LIVERPOOL BAY CCS LIMITED'S - HYNET CARBON DIOXIDE PIPELINE PROJECT

SUBMISSION OF CHESHIRE WEST AND CHESTER COUNCIL FOR EXAMINATION DEADLINE 4 (20 June 2023)

Draft DCO Requirement 13 – Construction Hours

**DRAWING TITLE**  
**WORKS PLAN REGULATION 5(2)(i) APPLICATION DOCUMENT REFERENCE D.2.4 SHEET 3**

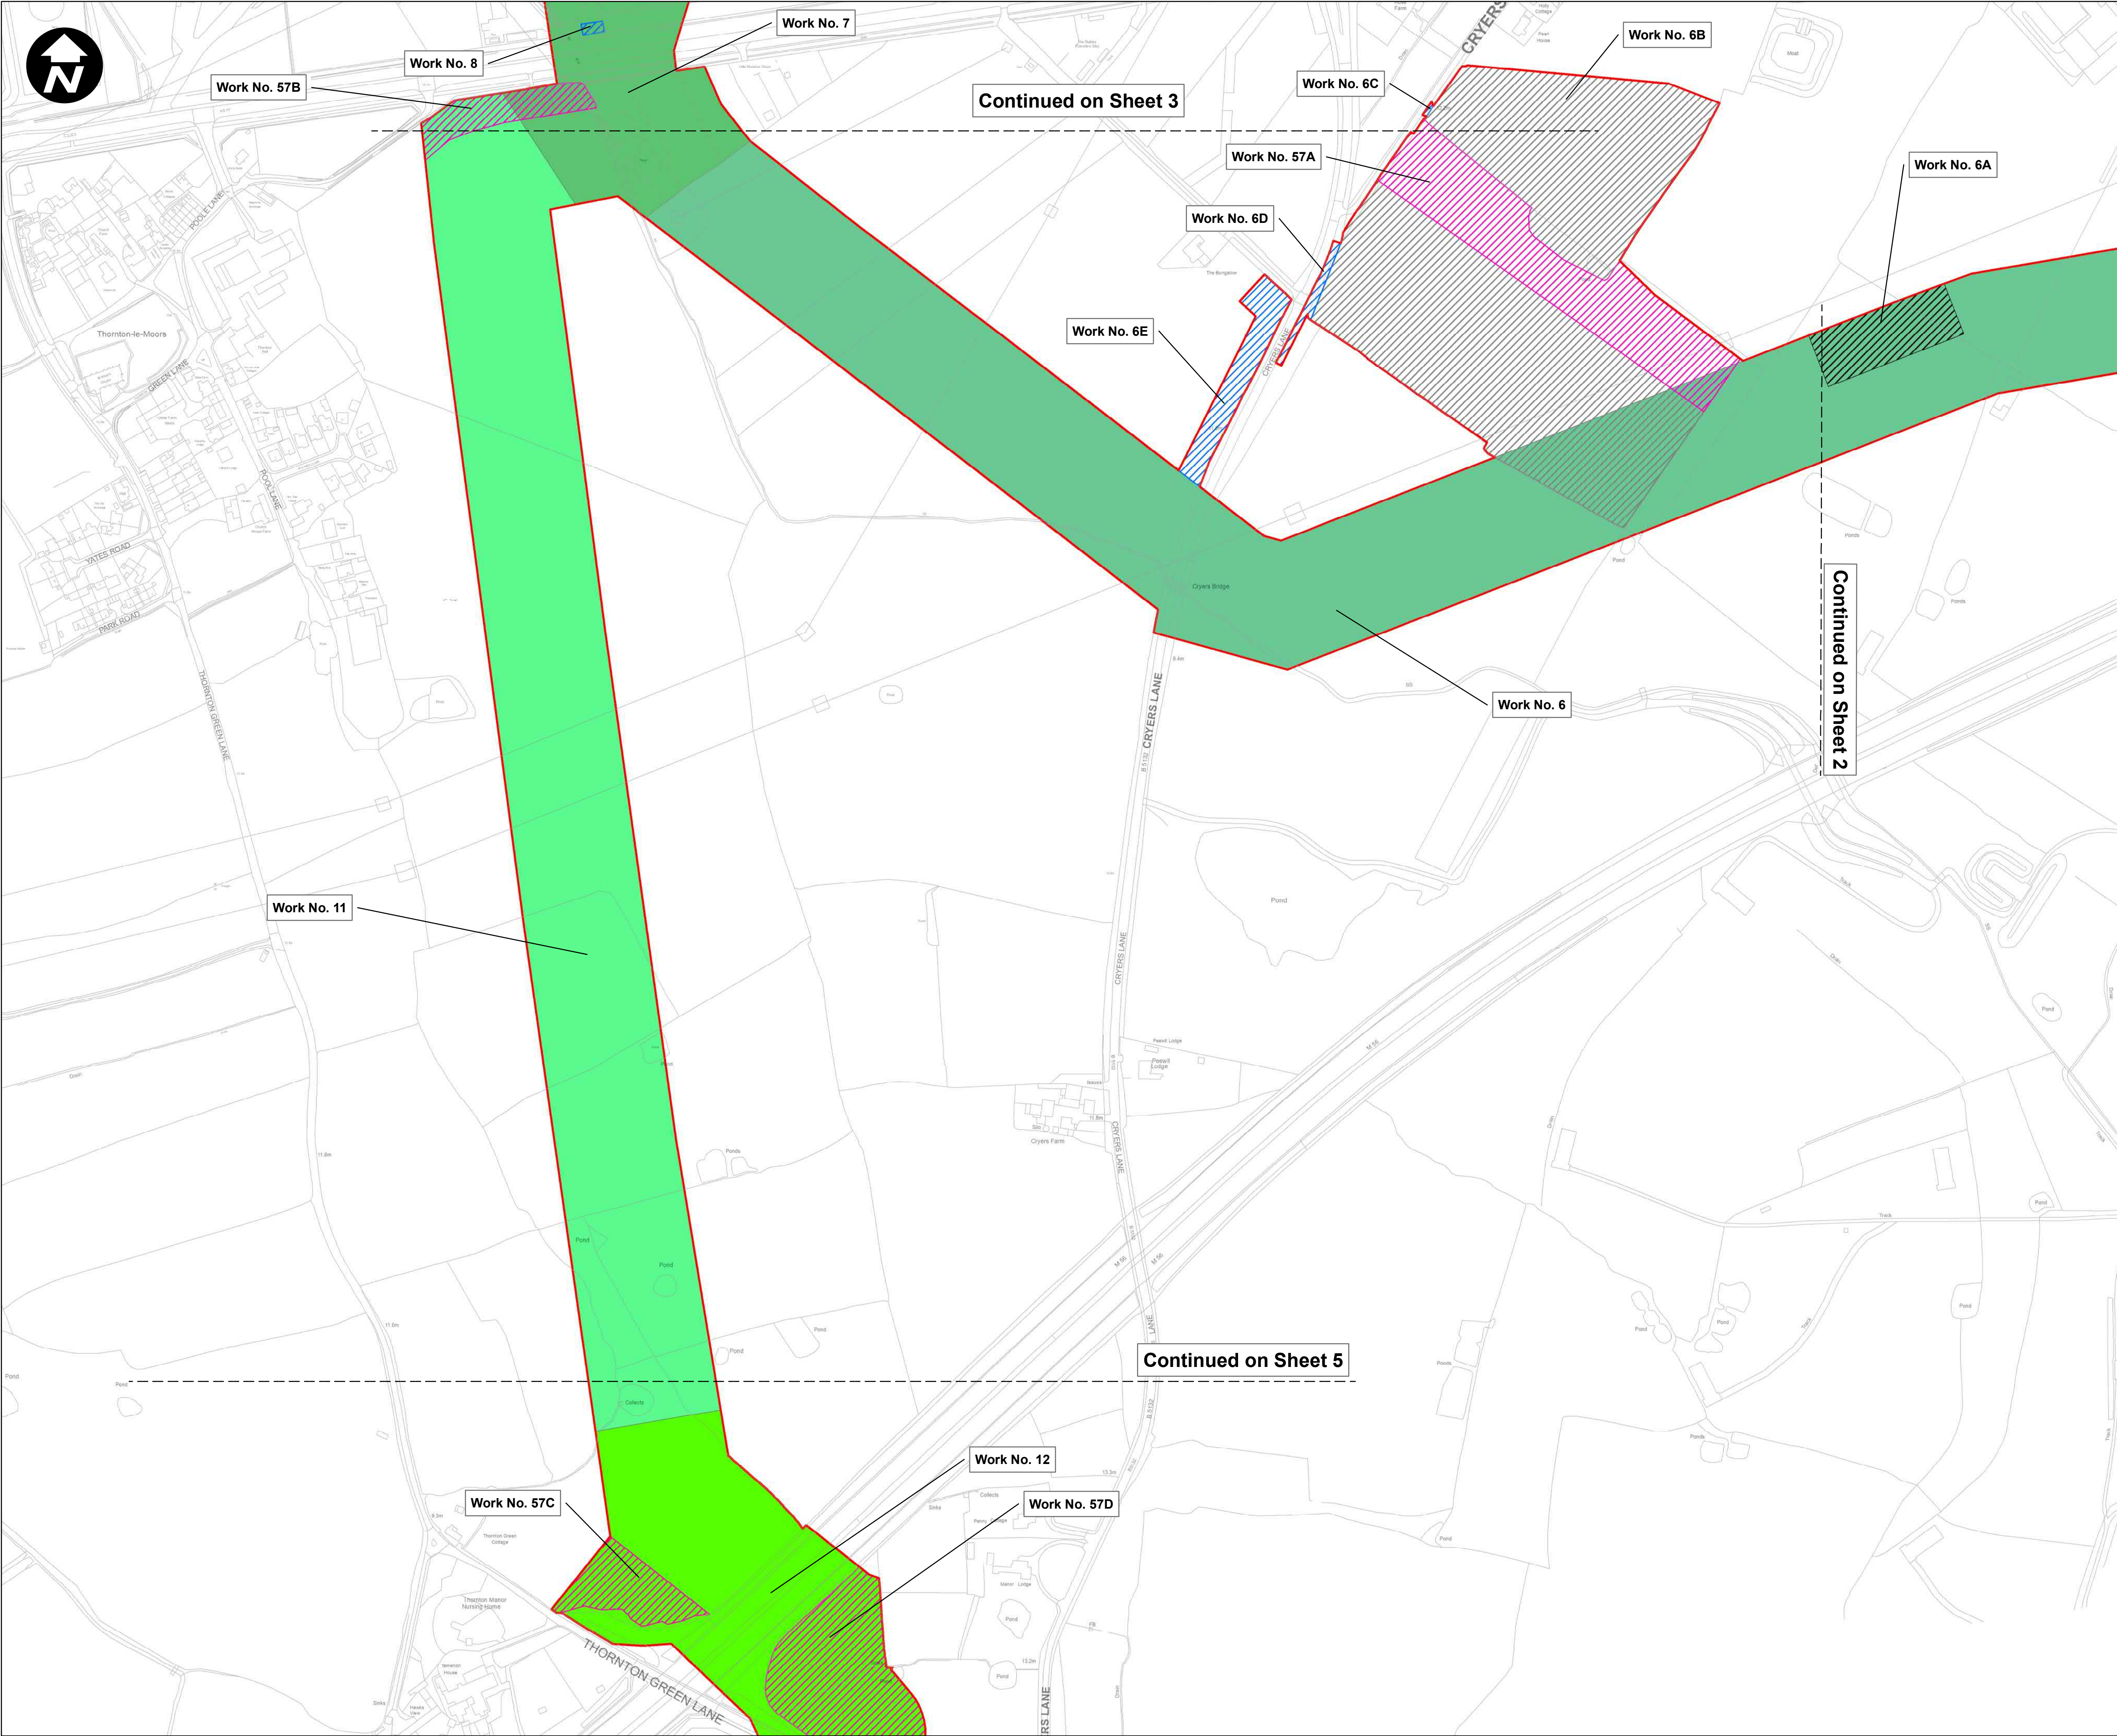
Whilst the Council accepts that certain operations including continuous drilling will be required as part of the Project, the Council’s concerns lie where such continuous operations occur in very close proximity to residential uses and in particular residential caravans. This issue is particularly highlighted where an established traveller site lies immediately adjacent to the order limits and the trenchless crossing of the A5117.

Works Plan dwg no. EN07007-D.2.4-WSP- Sheet 3 [REP2-005]. Ariel map with DCO overlay.

The criteria for when mitigation including re-homing for significant noise impacts will occur is set out in paragraphs 15.10.3, 15.5.30 and 15.5.56 of Chapter 15 of the Environmental statement [APP-067]. Whilst this is accepted as appropriate for housing, it is not accepted for caravans. Without further clarification and consideration of the scale, type and likelihood of uninterruptible trenchless operations and consideration for any specific mitigation, including appropriate criteria for this, and potentially other sensitive locations, the Council remains concerned in respect the current wording of Requirement 13.

To address the above, the Council suggests that the OCEMP further define uninterruptible trenchless operations and specify the need for a “Special Cases” statement, or similar, to be provided as part of the noise and vibration management plan, as part of the final CEMP, and that this is referenced in the definition of “trenchless construction techniques which cannot be interrupted” under Requirement 13. The “Special Cases” statement should include the requirement for the identification of any buildings and/or their occupants which may not be adequately protected by the thresholds set out in Para. 15.5.30/15.5.56 of Chapter 15 of the Environmental Statement [APP-067], including people dwelling in caravans, and should include and site-specific noise trigger levels and/or alternative noise control measures.
